Reference No:	<b>2023/62/93724/E</b>
Site Address:	3, Knowler Hill, Hightown, Liversedge, WF15 6PH
Description:	Erection of first floor rear extension with external alterations
Recommending Officer:	Nicole Helliwell

## **Officer Report**

**Reference No.** 2023/62/93724/E

**Proposal:** Erection of first floor rear extension with external alterations

NOTES:

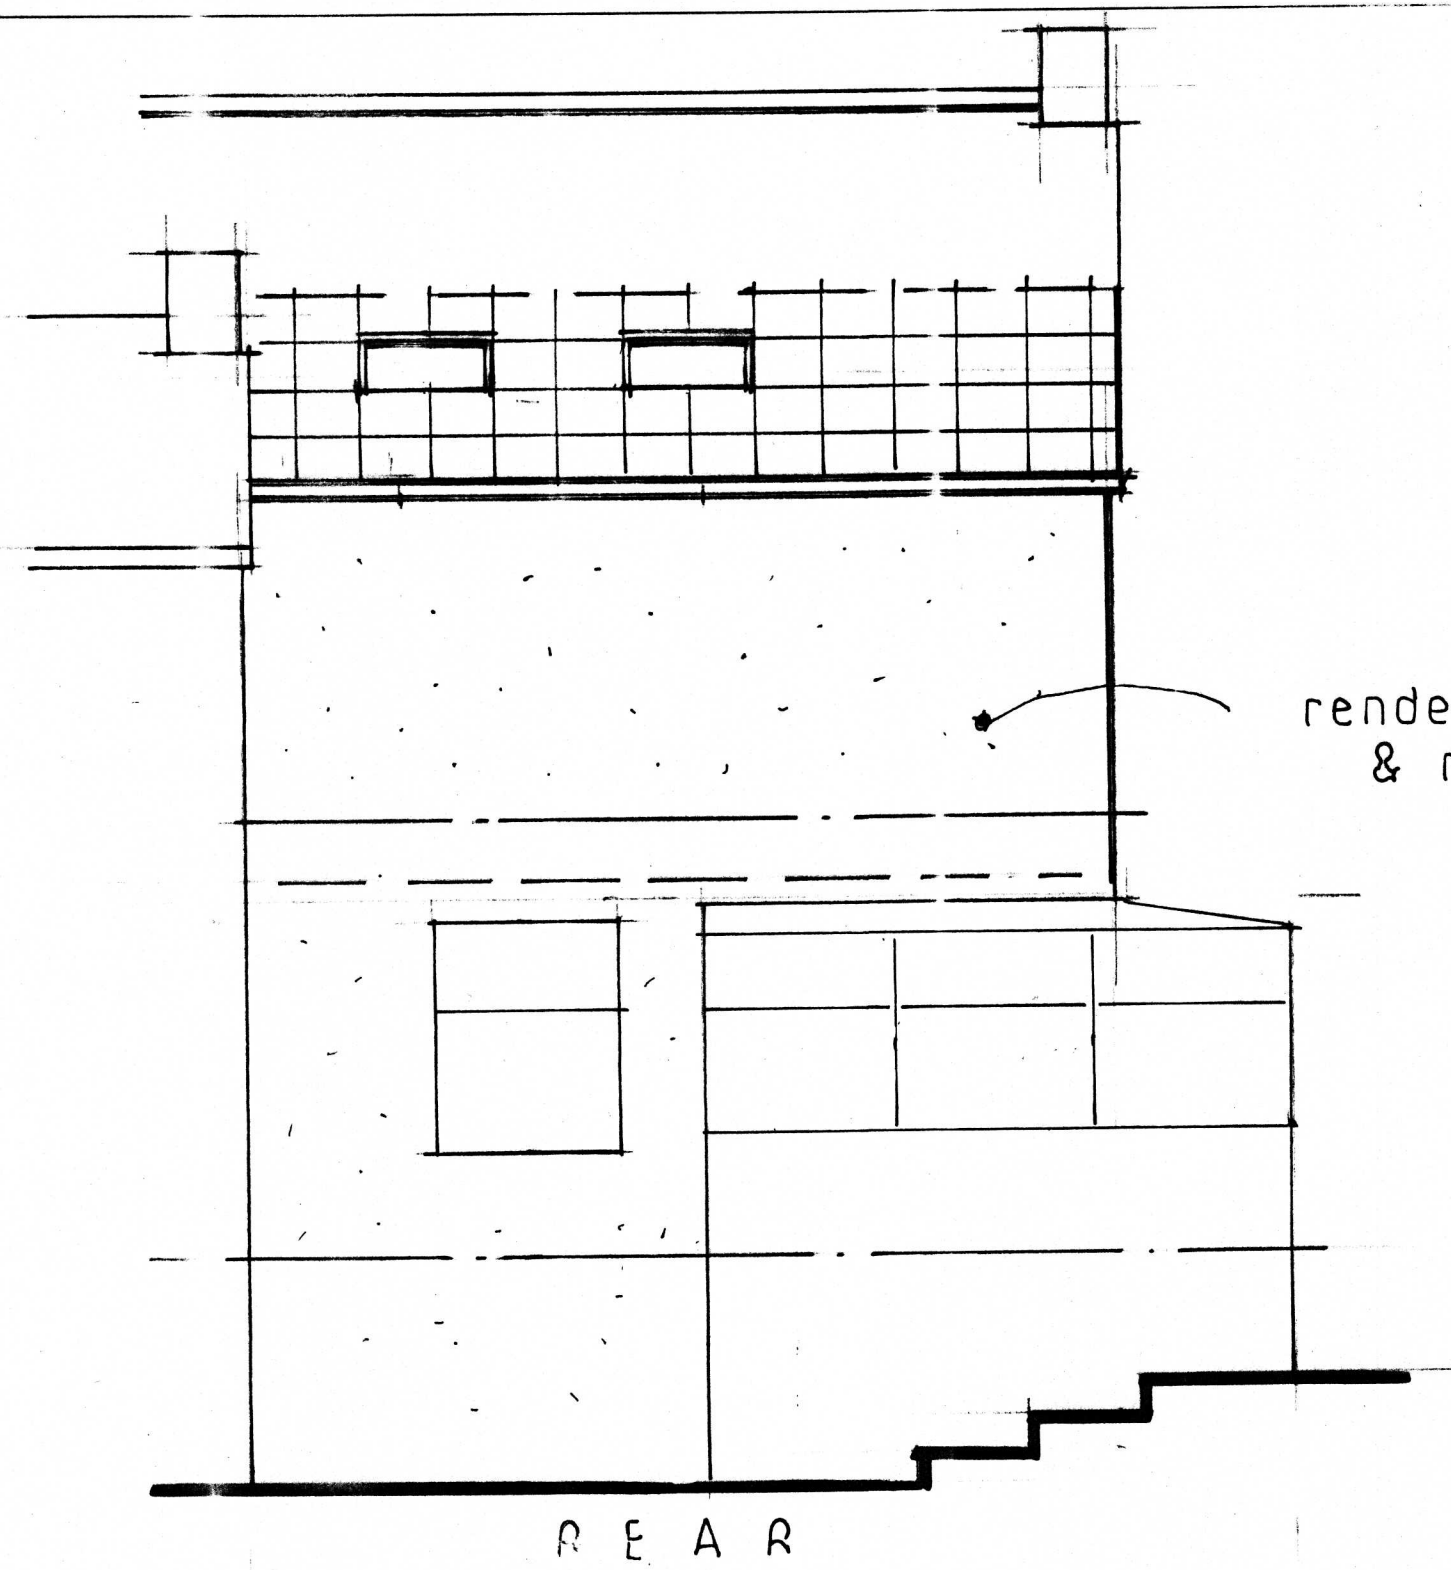
Amendments were sought during the course of the application. A request was made to alter the materials proposed for the side elevation of the extension to red brick to match the appearance of the original build. Furthermore, a request was made to install a first floor window within the rear elevation of the enlargement to improve the occupier's residential amenity. Revised drawings were received which were considered acceptable with regard to visual and occupier amenity.

3. The extension hereby approved shall be faced in render for the external walls with the exception of the side elevation which will be faced in red brick. The roofing materials will also be slate. The materials of construction shall thereafter be retained for the lifetime of the development.

4. The proposed first floor windows in the side elevation of the dwelling shall be fitted with obscure glazing to at least Level 3 on the Pilkington Scale and non-

opening to a height of no less than 1.7m above floor level and retained as such thereafter.
